Reference: H05-0326-20 **Date of Decision:** 10th July 2020

Applicant: Gem-Mix Holdings Ltd
Gemmix Ltd
Eldernell Lane
Coates
Peterborough
PE7 2DD

Location: 37 Fleet Road Fleet Spalding Lincs

Description: Erection of 3 pairs of semi detached 3 bed dwellings along with up graded site entrance and road way, car parking and bin storage - re-submission of H05-0572-19

DRAWING TITLE:
PROPOSED SEMI DETACHED 3 BED
PLANS AND ELEVATIONS PLOTS
3-4-5-6

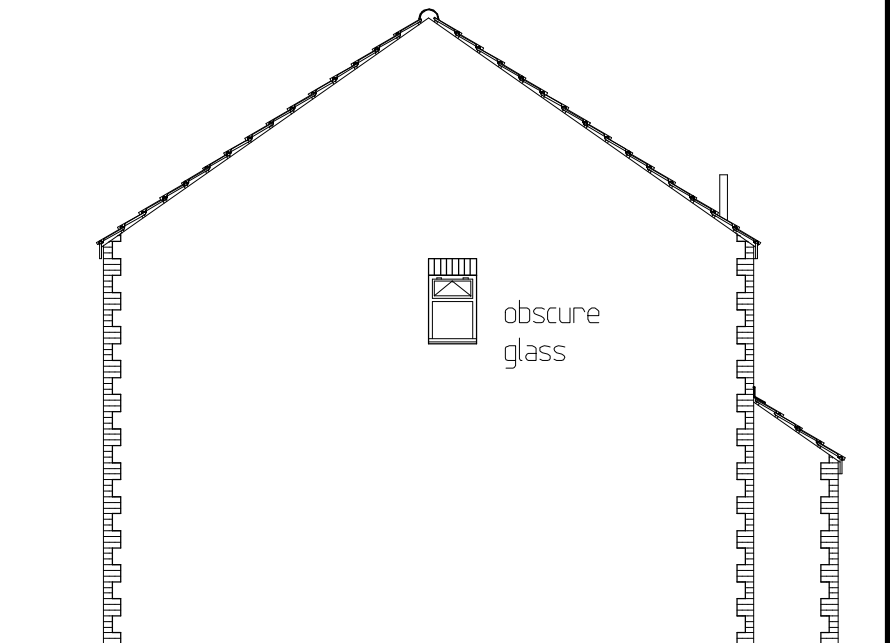
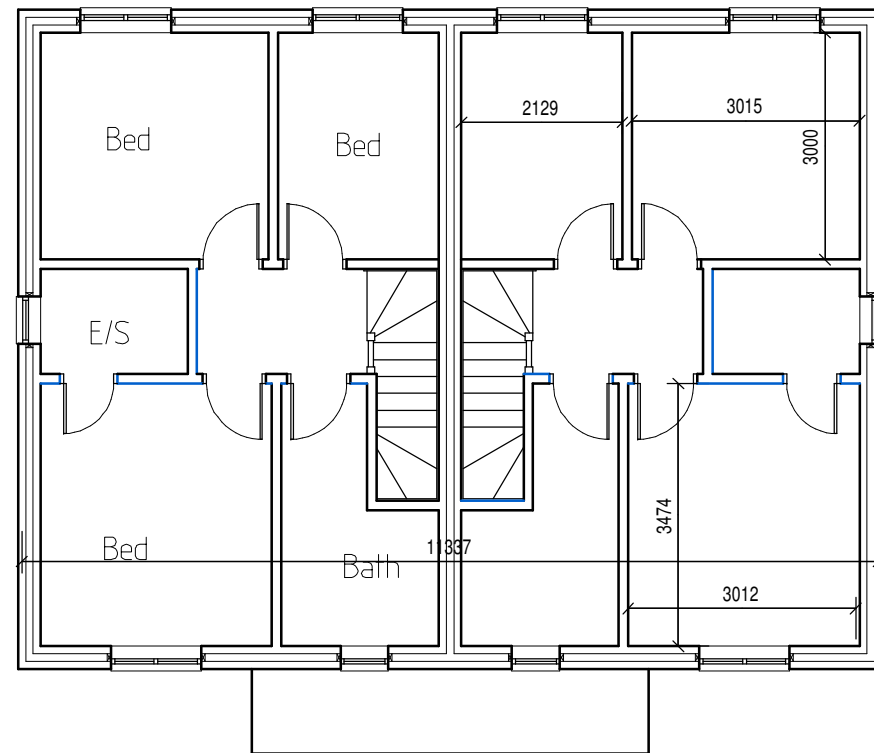
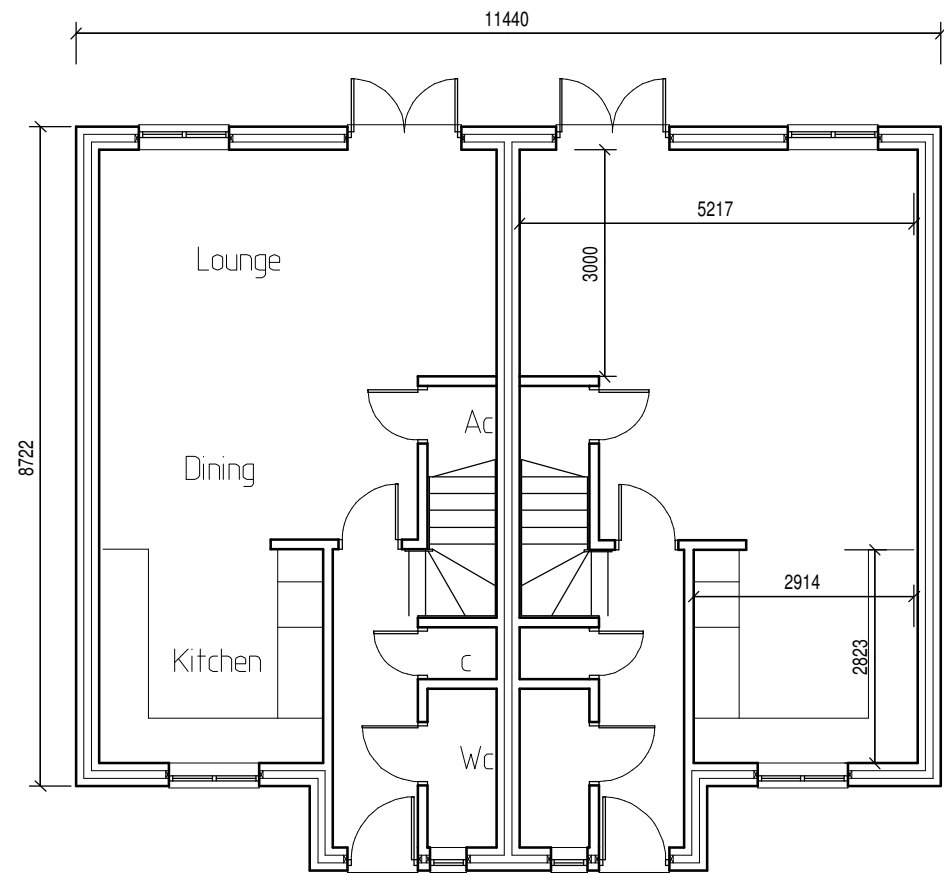
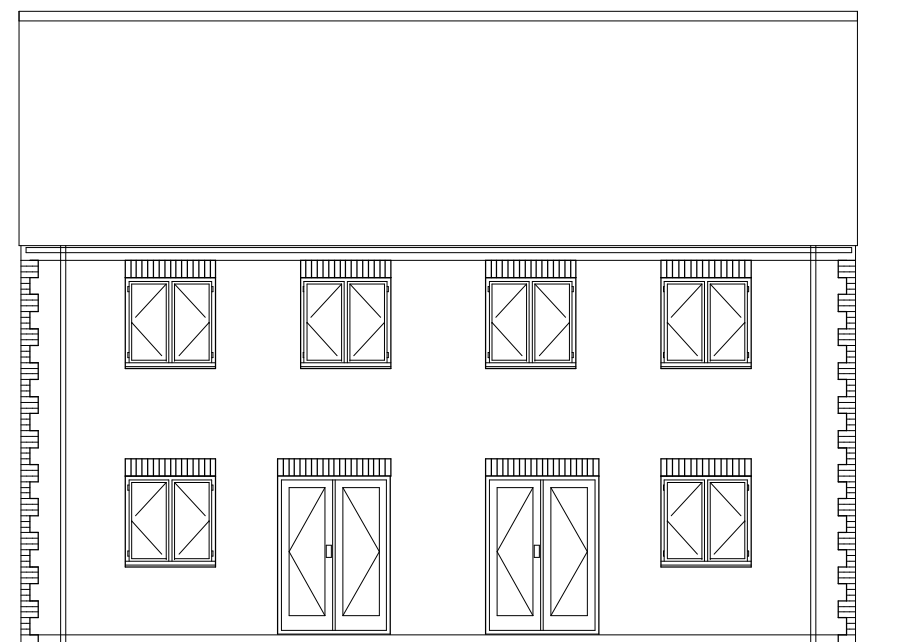
- 3 The footprint of the houses in Plots 5 and 6 will only be set back approximately 1.12 metres from the eastern boundary of the site. The nearest properties will be No's. 11 and 12 Grimwood Close. It is considered that, on balance, the maximum height of 8.40 metres of the proposed houses will appear excessive given the separation distance of approximately 10.65 metres to the nearest existing properties.

DRAWING TITLE:
PROPOSED NEW SITE
LAYOUT

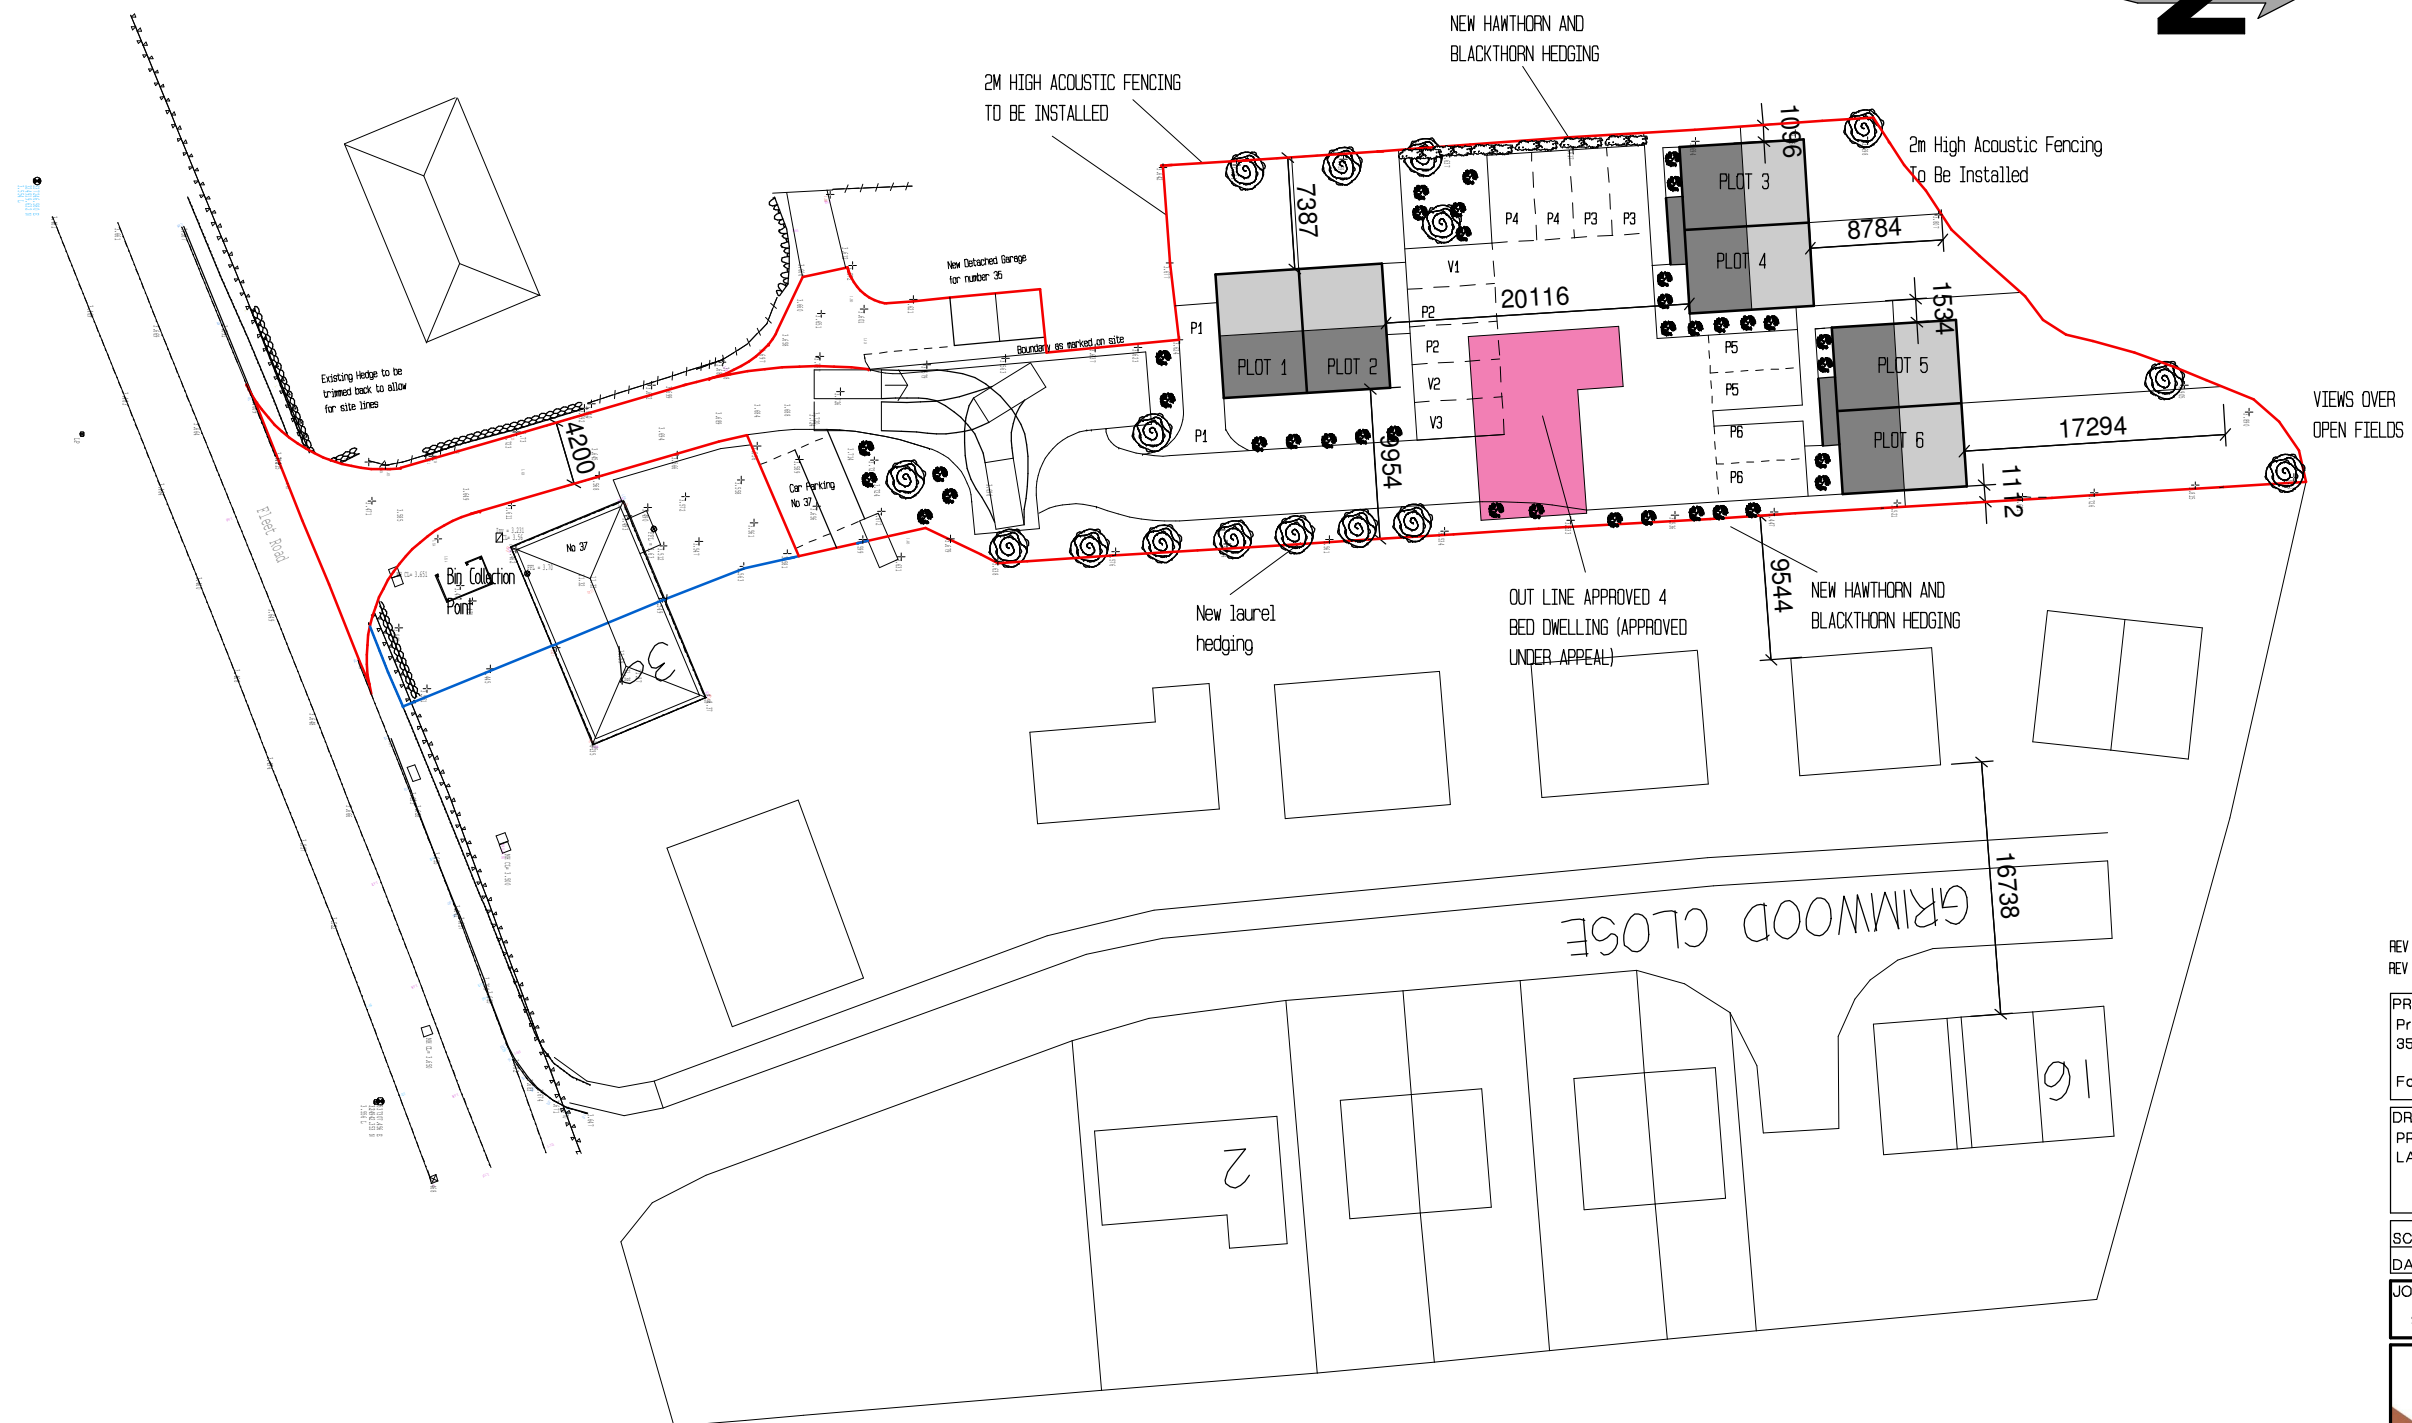
- 1 The application site is adjacent to the premises of JML Henderson Ltd, a business use on the neighbouring Fleet Road Industrial Estate. It is understood that regular HGV and forklift movements take place in the early hours of the morning in the storage facilities on the site. This is alongside its usual daytime business activities.

These facilities are approximately 7.60 metres from the site boundary. In addition, the nearest proposed dwellings to this boundary range between 7.38 metres and 1.09 metres away.

Secondly, in the Appeal Decision APP/A2525/W/17/3176758, the inspector stated that "a large area of the existing garden at No 37 would be retained as amenity space" and "the future occupants of the dwellings to the east would still experience a relatively open aspect in views from the rear of the dwelling and gardens". The appeal was allowed on the basis of a single dwelling. However, this application will clearly entail the construction of further 5 dwellings across the entire site and consequently the open aspect referred to be the Inspector would not exist and significant harm will occur to the residents of houses in Grimwood Close by reason of overbearing impact, especially due to the positioning of Plots 5 and 6.
